Your Ref: OWPC19517
Our Ref: K/23/18/PL 12-06-2018
Please ask for:
Mrs A Gardner

Demolition & erection of 1 No. dwelling with swimming pool.
Little Deerswood Gorse Avenue East Preston

Thank you for your internet representation made on 6th August 2018 which has been recorded as '**an objection**' with the comments as follows:

Site Plan as proposed

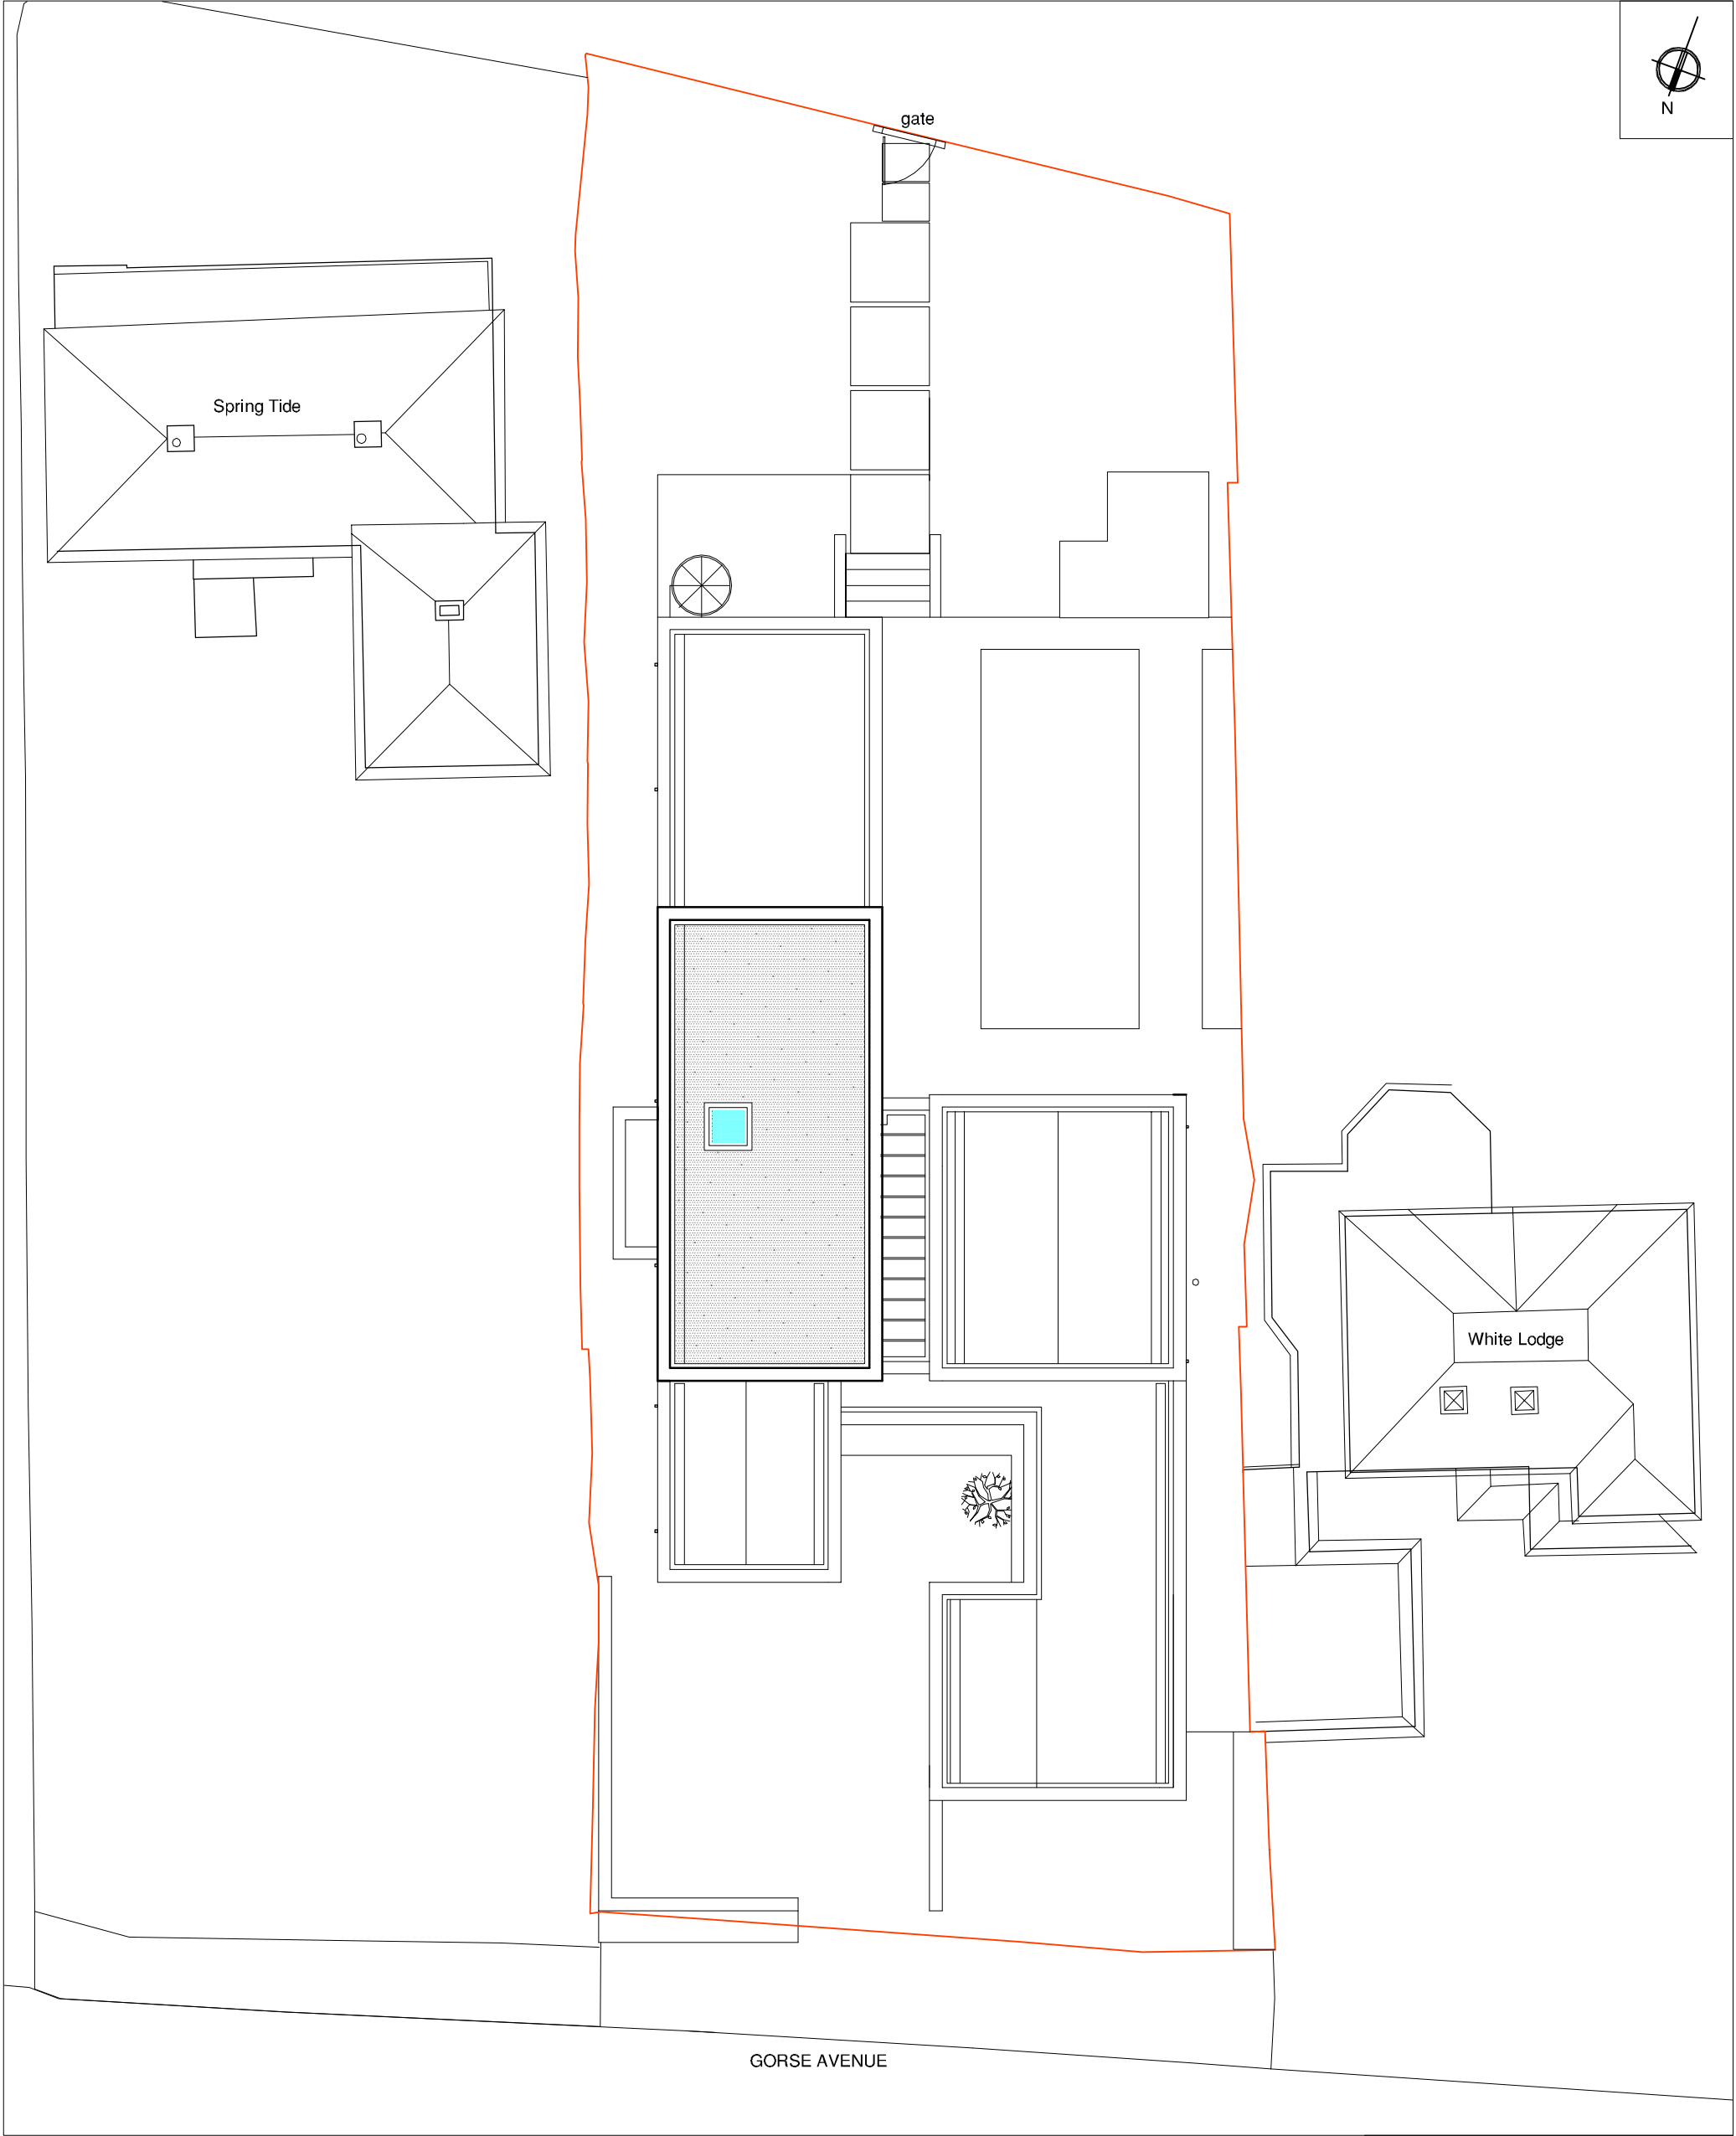
1) I note that the new property will significantly extend to the south, well beyond the building line of the existing property that is to be replaced. Such a development impact my outlook to the east as well as that of the other properties to the west of the proposed development. To my knowledge in the past any previous development on the estate has had to contain itself so that it did not extend further south than existing the existing property or the general building line of other neighbouring properties.

South & West Elevations as proposed

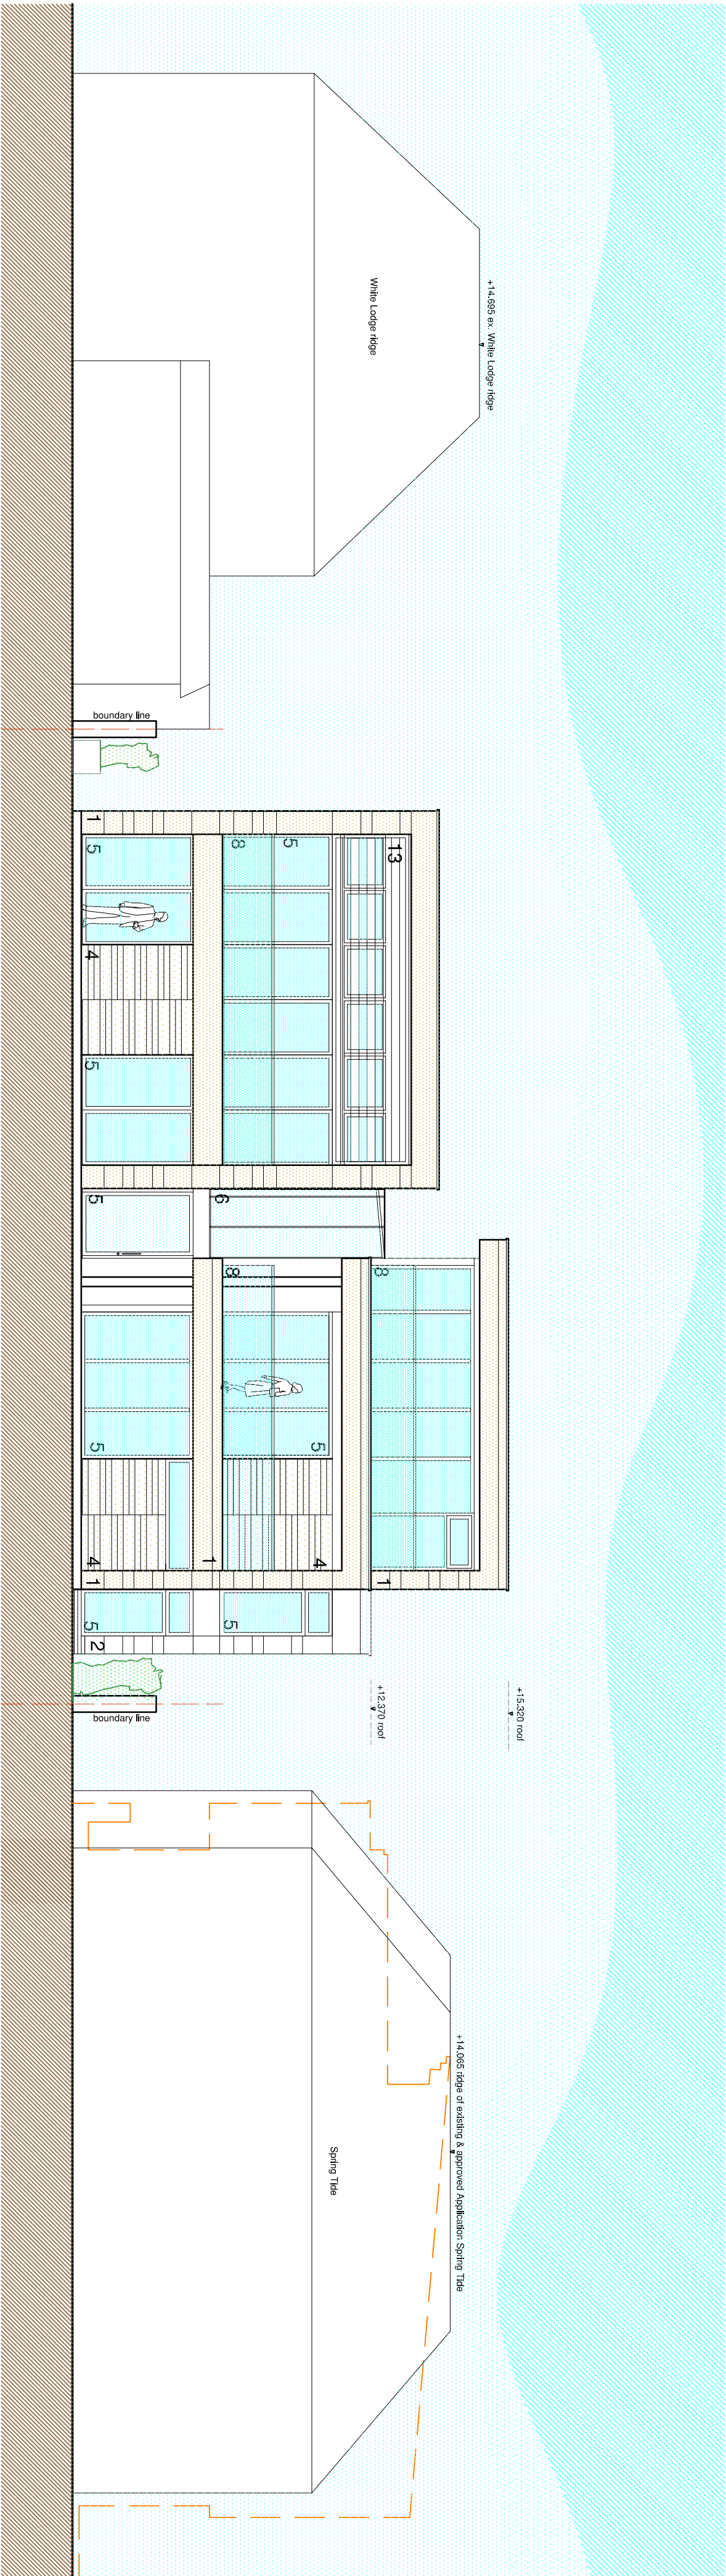
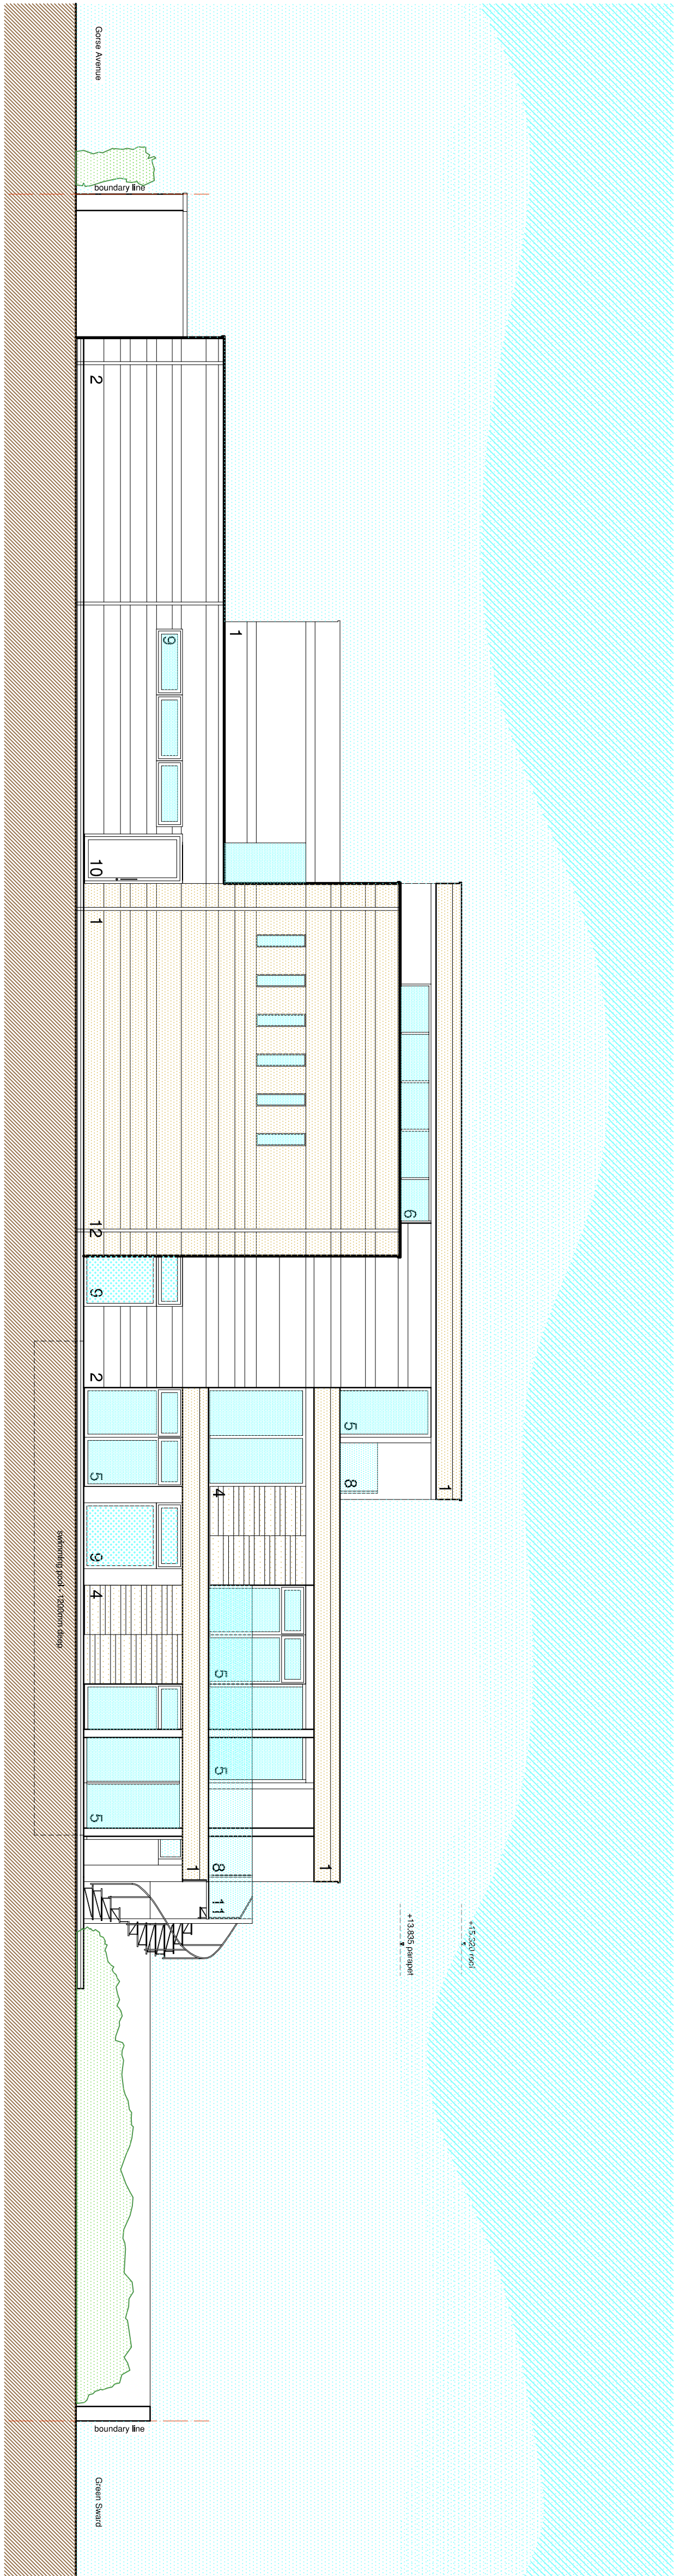
2) The proposed design of the new development, with the significant extension to the south and the two/three story design with multiple windows and balconies on the west extension, will significantly impact our privacy and the privacy of our adjacent neighbours. The proposed locations of the windows and balconies across 3 floors will provide multiple direct lines of sight into the windows of all of our existing south facing bedrooms and across the breadth and depth of our outside living space and that of our neighbours. This is unacceptable. I would not expect new properties to have such an extensive outlook over other neighbouring properties.
